Ribble Valley Borough Council  
Housing & Development Control

Application no: **3/2021/0555**

Address: **42 Knowsley Road Wilpshire BB1 9PN**

Proposal: **Proposed change of use from Residential Class C3 (dwellinghouse) to C2 (residential institution).**

Drawing Title
Existing Details

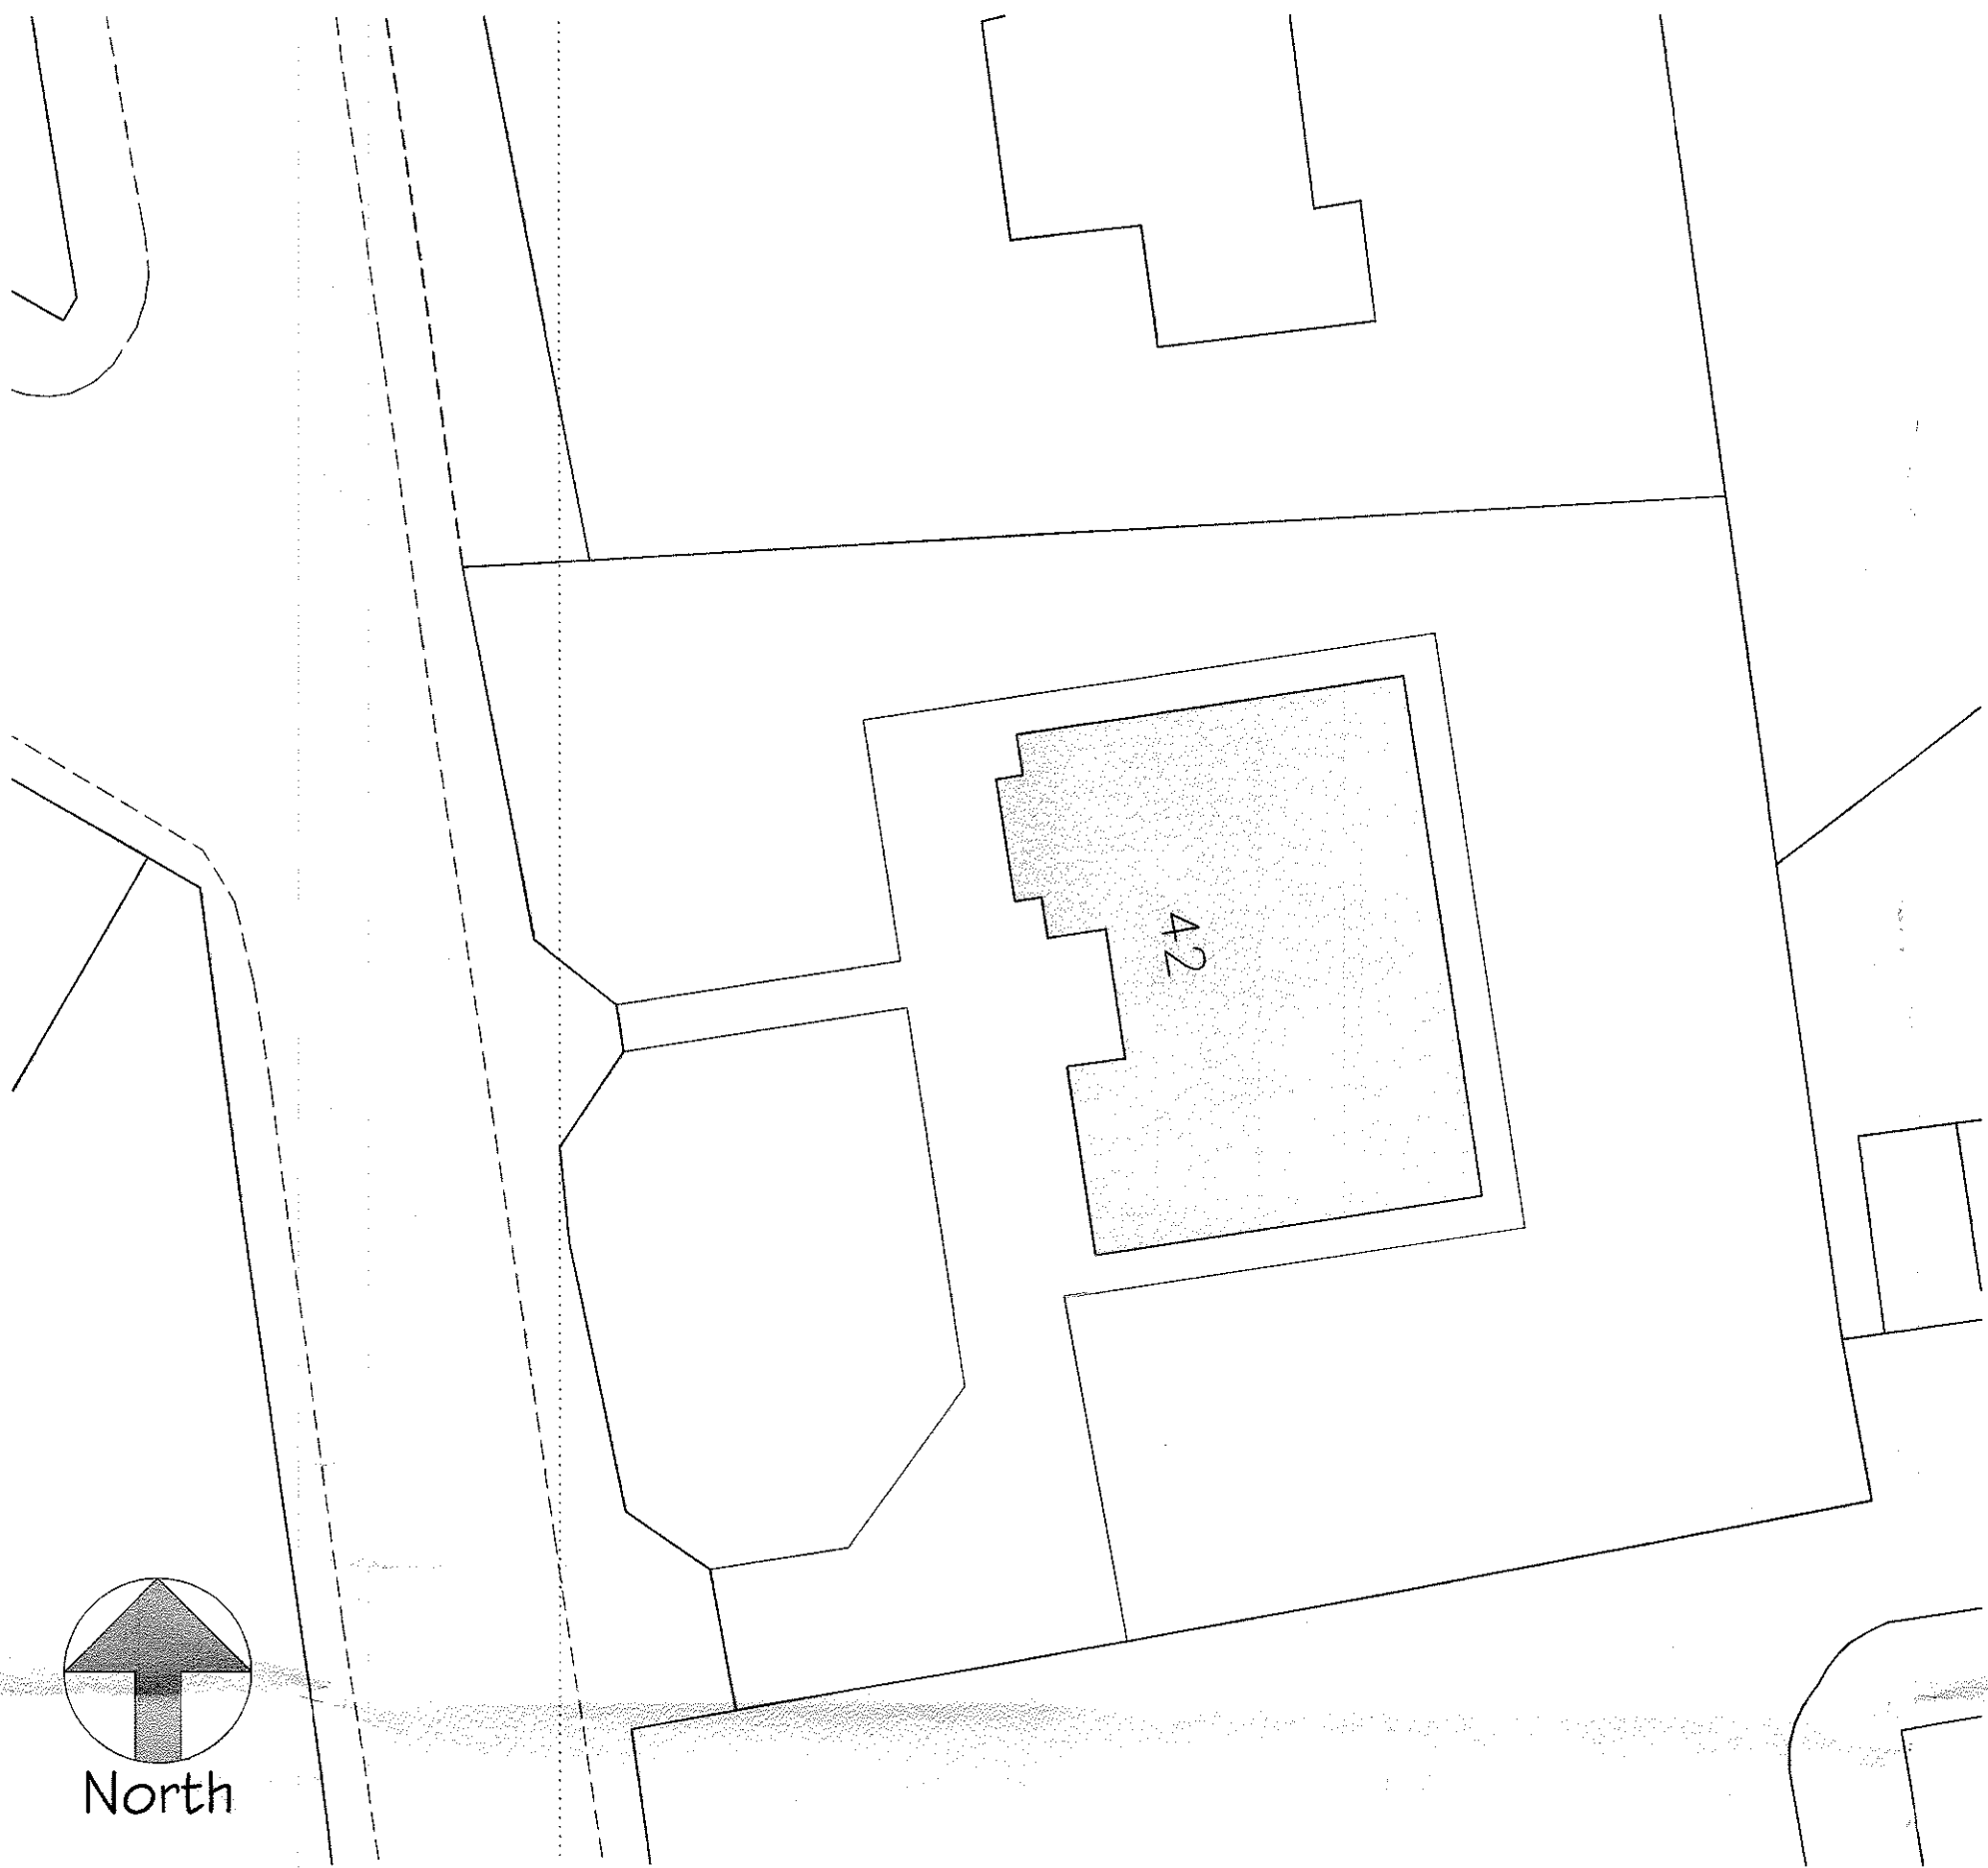
While the LHA have no concerns regarding the access width at the site, the LHA note that the access will remain gated following the proposal. The LHA have measured drawing number SW\_101 titled "Existing Details" and understands that the gate will remain a setback a distance of 4m from the public highway.

However, to comply with the LHAs guidance, a gate for a residential institution is required to be setback a distance of 5m from the public highway. While the LHA are aware that the current shortfall is only 1m, the minor intensification of use of the access requires the gate to be setback the required distance from the public highway and therefore the LHA will condition this request.

However, the LHA have reviewed the supporting documents including Stones Young drawing titled "Floor Plan" and drawing number SW\_101 titled "Existing Details" and understands that only 3 car parking spaces can be provided on site. 2 of the spaces can be located on the driveway while the other space can be located in the single garage which measures 4.45m x 6.38m as shown on Stones Young drawing titled "Floor Plan".

1. Notwithstanding the provisions of Part 2 of Schedule 2, Article 3 of the Town and Country Planning (General Permitted Development) (England) Order 2015 (or any Order revoking and re-enacting that Order) no vehicular access gates, barriers, bollards, chains or other such obstructions shall be erected within a distance of 5 metres of the highway boundary, nor shall any be erected within a distance of 5 metres of the highway boundary unless hung to open away from the highway.
